From: Guy Storey [REDACTED]
Sent: 04 November 2019 18:07
To: Richard Castro-Parker <Richard.Castro-Parker@arun.gov.uk>
Cc: Juan Baeza <Juan.Baeza@arun.gov.uk>; James Smith <[REDACTED]>
Subject: RE: Yeomans Honda consultee comments.

Subject: Yeomans Honda consultee comments.

Drawing
PROPOSED SITE PLAN

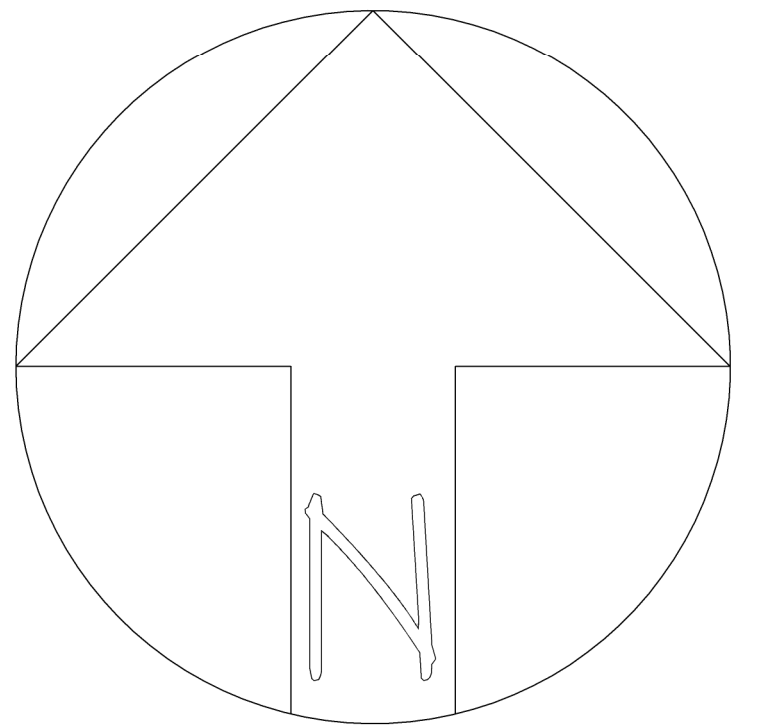
In principle, the Local Highway Authority (LHA) has no concerns with the proposed works, however the applicants needs to ensure that none of the works will be within the extent of public highway. There seems to be some inconsistencies between the existing features on the proposed plan and what is present on the ground. The block plan demonstrates the existing slot drain at southern access aligns with the existing dwarf wall. This does not seem to be the case on the ground. This makes it difficult to establish if any of the proposed works, namely at the southern access point, will take place on the public highway.

The LHA would ask this is clarified by the applicant, so that suitable informative can be provided if required.

I can confirm that none of the works will take place on the public highway.

Drawing
SECTION THROUGH FORECOURT

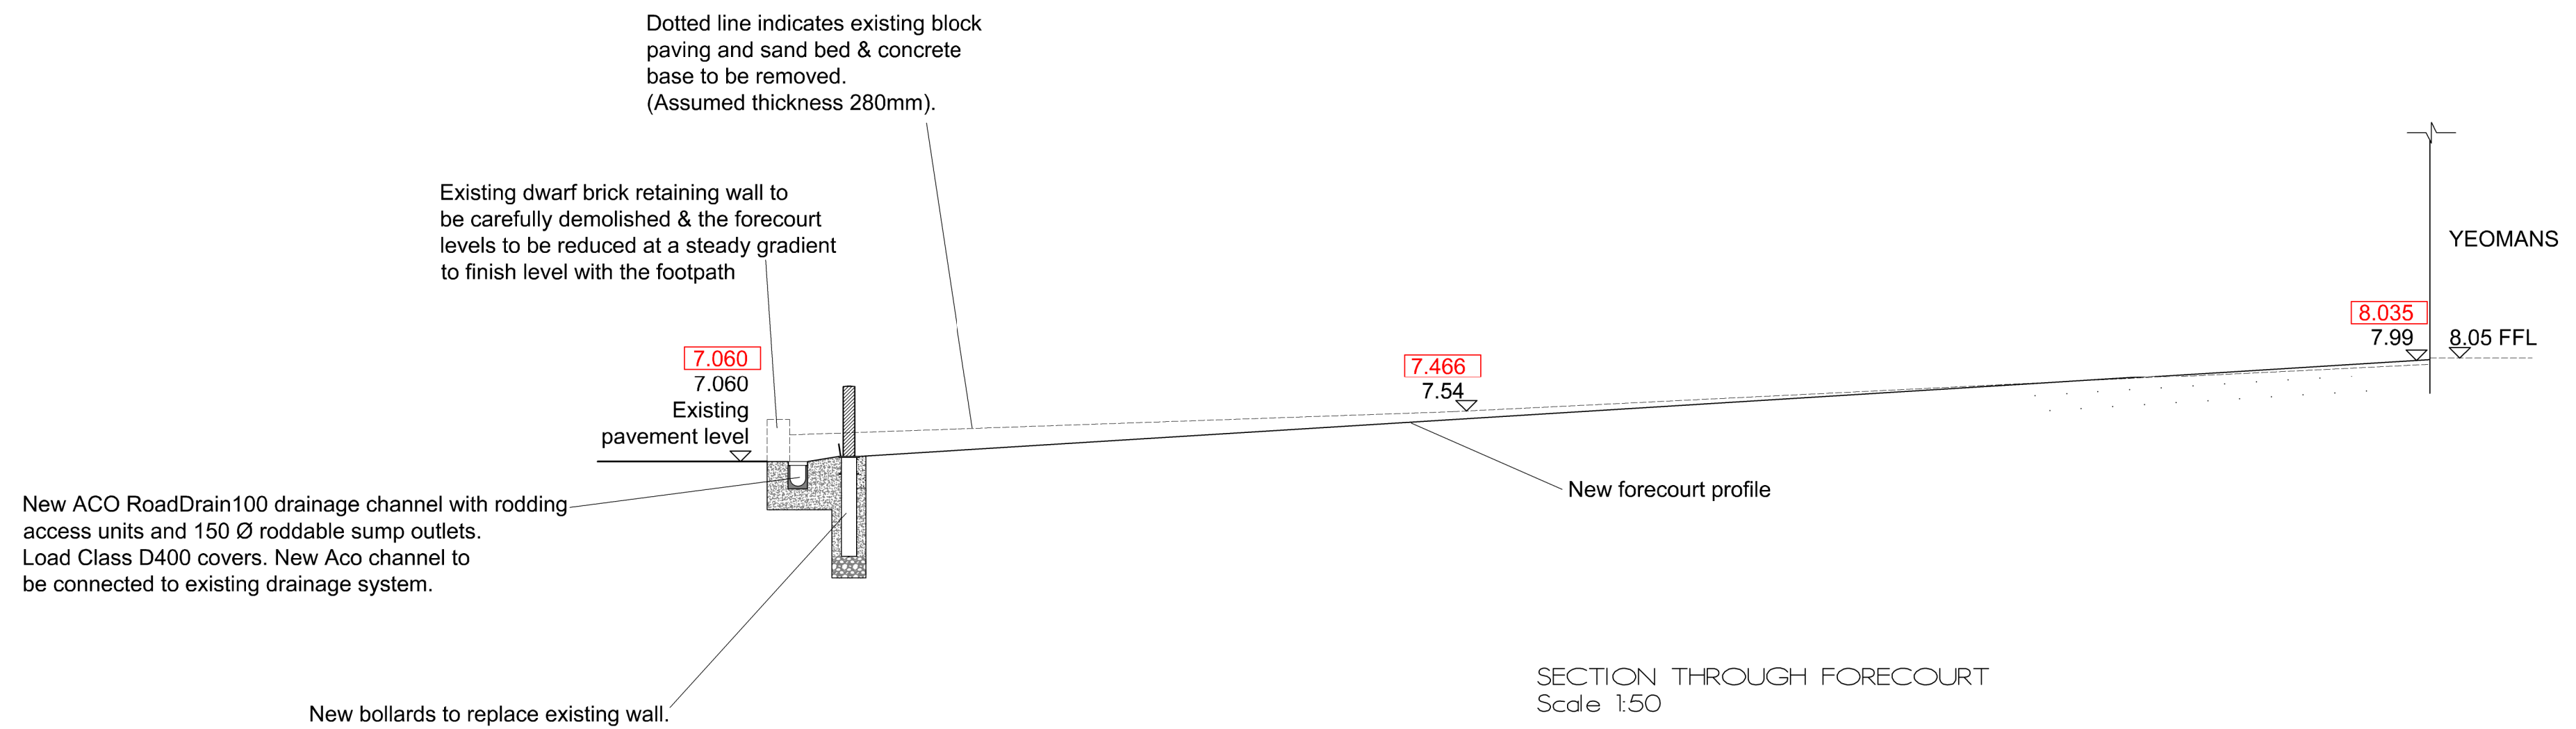
It would seem that the area was suitably remediated as part of the Permitted change from petrol filling to forecourt some years ago (the Applicant informs me that the fuel tanks were slurry/grout filled). The tanks are still in place and would be in the area now being changed in terms of levels and so it would be unwise to disturb and/or infiltrate to the ground in this area, both for the existence of the tanks and for any pollutants that may exist outside of the immediate tank area.

The flow to main sewer (mentioned in my previous message) would seem to have been a requirement of the previous conversion, where the car washing effluent was required to go to the sewer with a commercial licence from Southern Water. There is no change in impermeable area (and therefore volume) being discharged to the sewer.

Therefore, if it can be shown that all of the above is correct with the new channel drains being connected via the same arrangements as previously and Southern Water have no concern regarding the revised arrangement, I have no objection to the proposals. It would be worthwhile ensuring a management plan was in place to ensure that the channel drains were cleaned out on a sufficient frequency so as to avoid the risk of direct discharge to the highway.

That the area was suitably remediated as part of the Permitted change from petrol filling to forecourt. The fuel tanks were slurry/grout filled. The tanks are still in place and would be in the area now being changed in terms of levels and so it would definitely be unwise to disturb and/or infiltrate to the ground in this area, both for the existence of the tanks and for any pollutants that may exist outside of the immediate tank area. I would point out again that the ground will not be broken to ensure that any potential pollutants will not be disturbed.

The discharge to main sewer was a requirement of the previous conversion, where the car washing effluent was required to go to the sewer with a commercial trade effluent discharge licence from Southern Water.

There is no change in impermeable area (and therefore volume) being discharged to the sewer.

The new channel drains will be connected via the same arrangements as previously.

As part of the works I can confirm that the existing on site drainage will be fully cleaned to ensure that it is operating correctly & that no direct discharge to the highway will occur.

The applicant has an ongoing drainage management plan whereby the drainage system & in particular the drainage channels are cleared of any silt or vegetation on an annual basis. I think that an advisory note requiring that the Applicant must ensure that no direct discharge to the highway occurs would be acceptable as is an existing requirement of the site operation.
